PLANNING OBJECTION

Application Number: 2026/62/92047/W
Land off Netherley Drive, Marsden, Huddersfield, HD7 6HL

Figure 6 Existing Clay Surface Water Pipes Found 11/06/26 (Blue arrows)

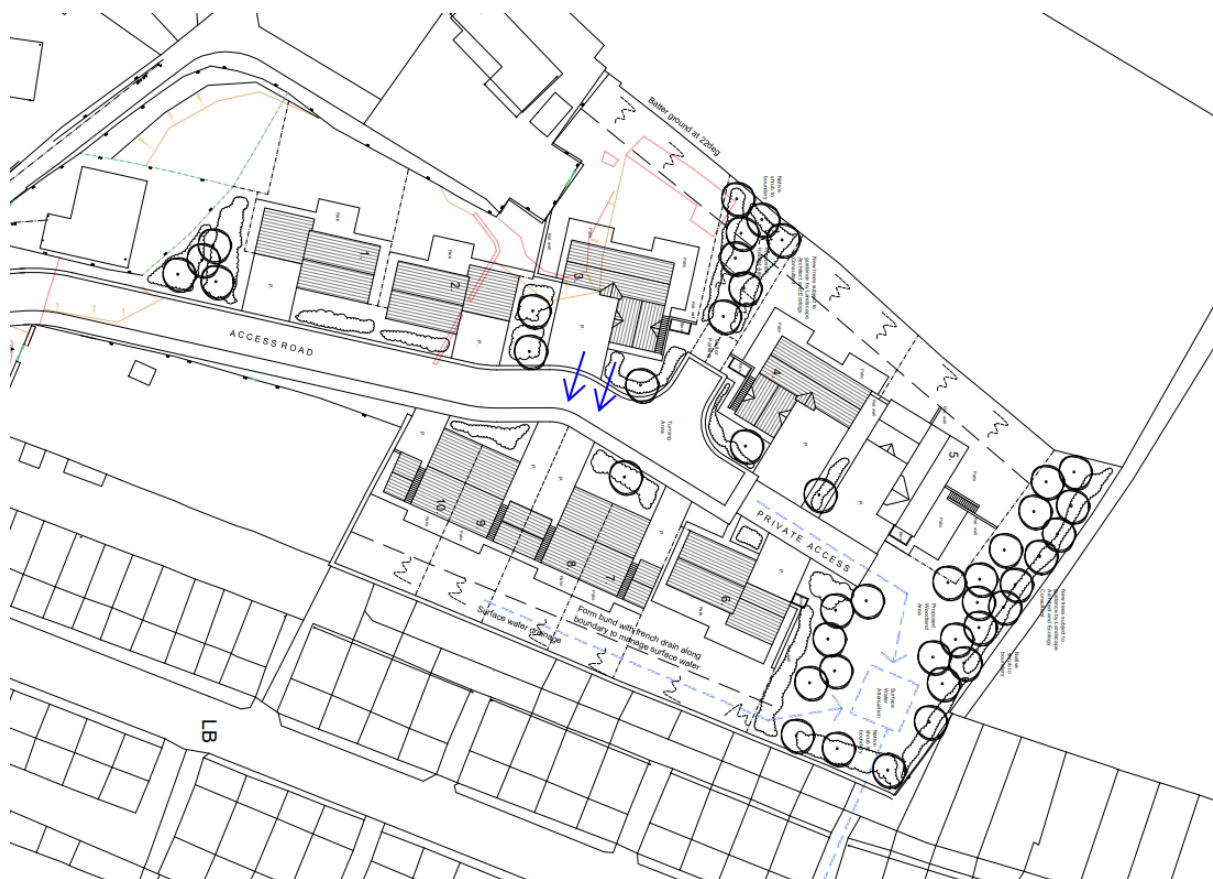
4.1 In contrast to the previous application, the applicant now relies on a Drainage Strategy report, which contends that there are likely drainage systems already on site. The report says "*A 4-inch / 100mm diameter clay pipe has been traced and verified as connecting to the existing 225mm diameter public combined sewer in Mount Road*". We note:

4.2 Evidence of the verification, including the location, has not been provided within the application. Further, no drains are marked across the site on Yorkshire Water's Asset Map.

4.3 The report is unable to explain what the newly discovered drainage on the site was used for and says (underlined for emphasis): "*The existing drainage encountered during trial pitting is therefore considered likely to comprise historic foul drainage, surface water drainage and/or land drainage associated with the former buildings and land use*". We do not consider this can be correct as:

4.3.1 The outbuildings referred to by the applicant as being present as late as 1999 were simply stables as the owner of Pule Springs kept horses (see **Appendix 1** and red-circled area of Google Earth image from 1999). The stables were located at a different location within the site than the historic Spout Ing farm buildings (see **Appendix 1** and red-circled area of Ordnance Survey map from 1932).

- 4.3.2 Pule Springs now occupies part of the original footprint of Spout Ing. The drains for Pule Springs & Butterley View adjacent do not run east to Mount Road, where the discovered clay pipes are said to run. Instead, they run to Netherley Drive.
